Project Name: Restoration of a Site
Address: 978 Washington Avenue
Applicant: Sadri Shir

On January 13, 2010, the Portland Planning Authority approved with conditions the restoration plan for removing a parking lot and restoring the site to its original topography at 978 Washington Avenue as shown on the restoration plan submitted by Sebago Technics dated 12-29-09 and revised 1-08-10. The conditions of approval are as follows:

**RESTORATION PLAN**  
OF: SHIR PROPERTY  
978 WASHINGTON AVENUE  
PORTLAND, ME  
FOR: SADR SHIR  
41 OCEAN HOUSE ROAD  
CAPE ELIZABETH, ME 04107

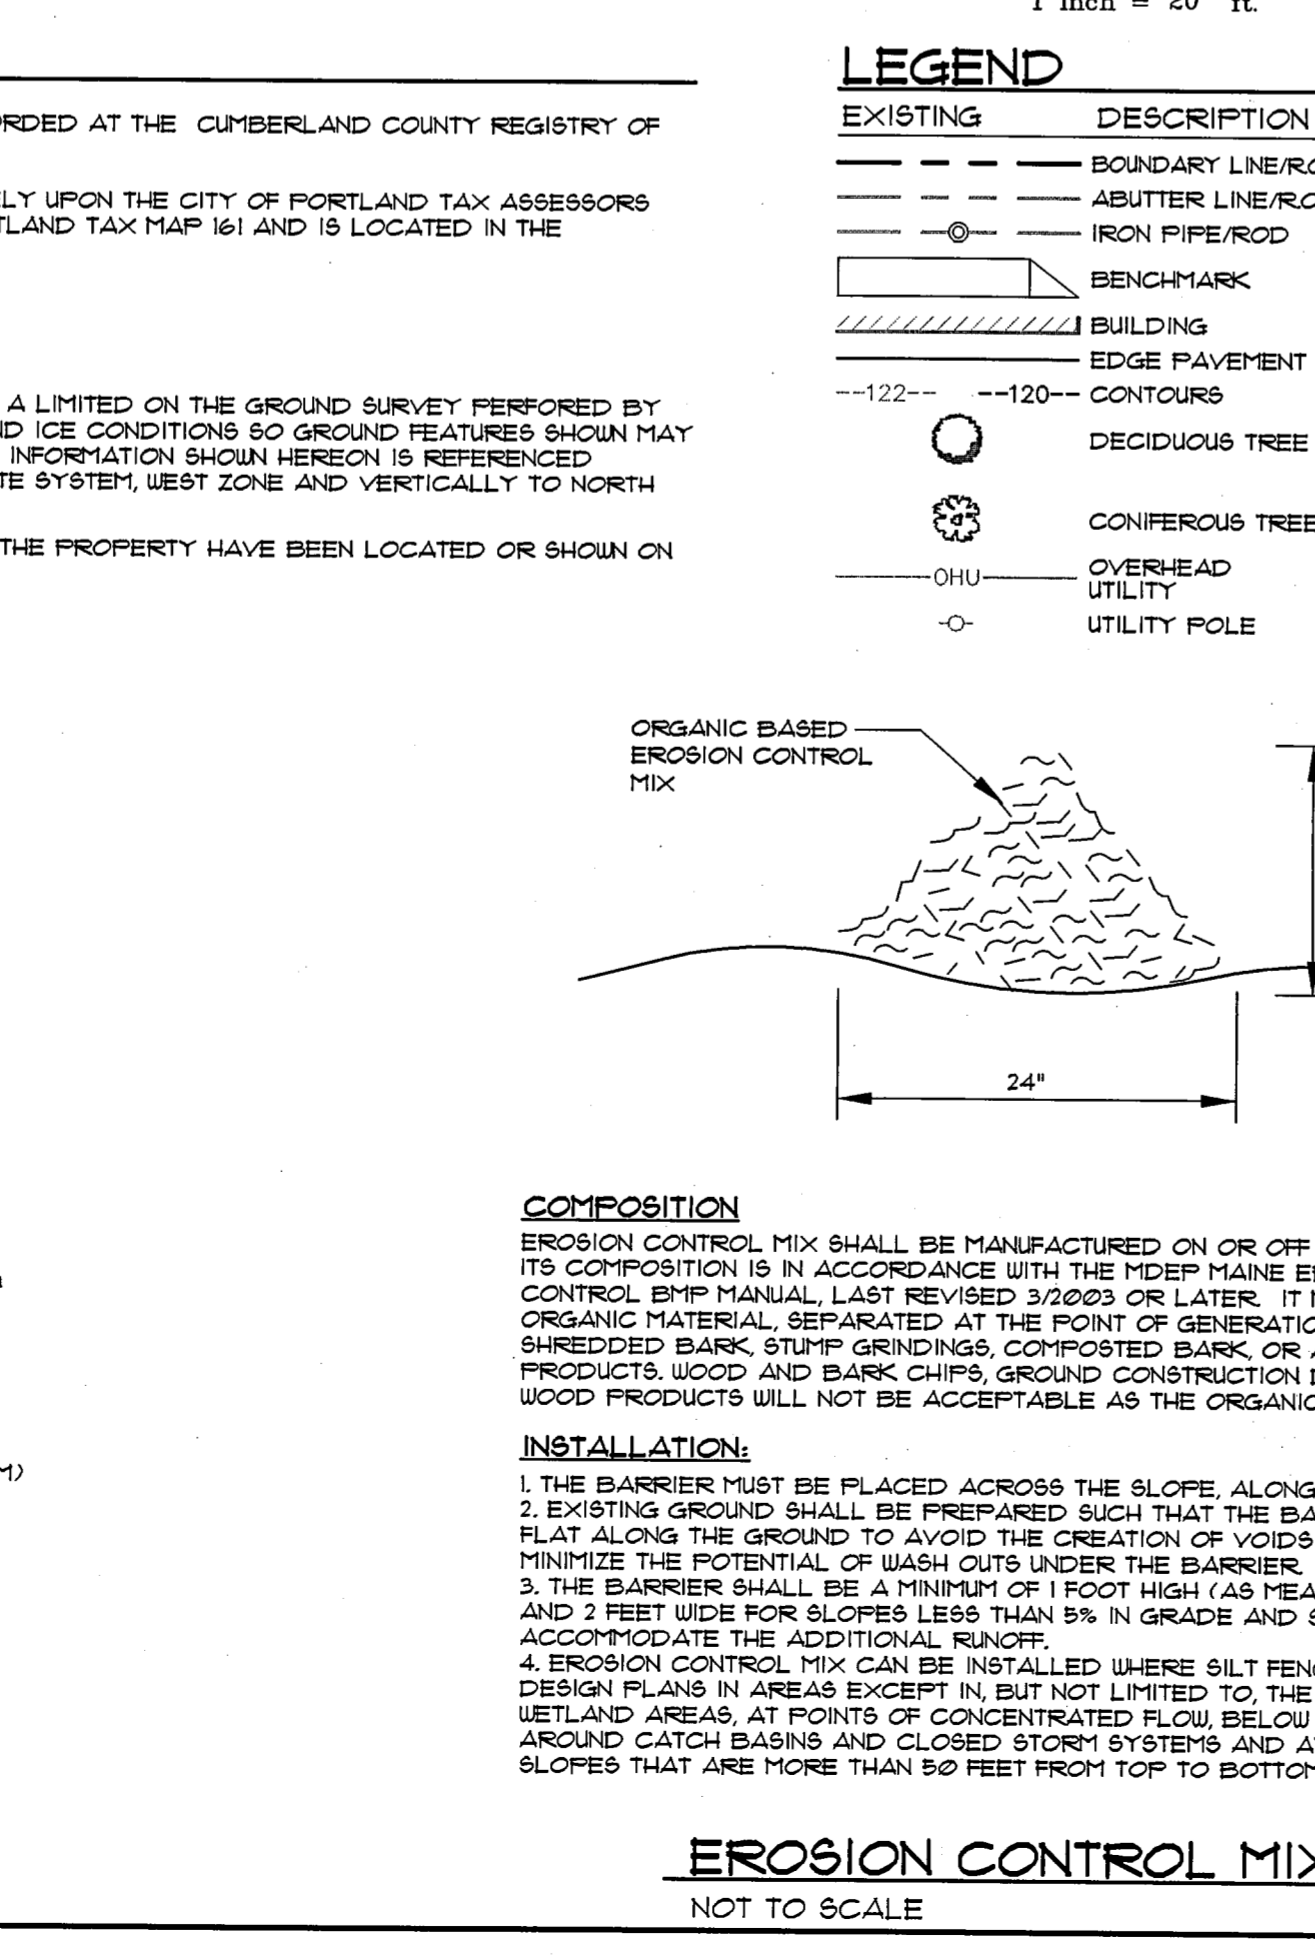
3. The site preparation shall include the removal of snow and installation of erosion control measures as shown on the restoration plan prior to the start of construction.

4. The applicant's consulting engineer shall confirm in writing that the final grades of the site are in conformance with the approved restoration plan.
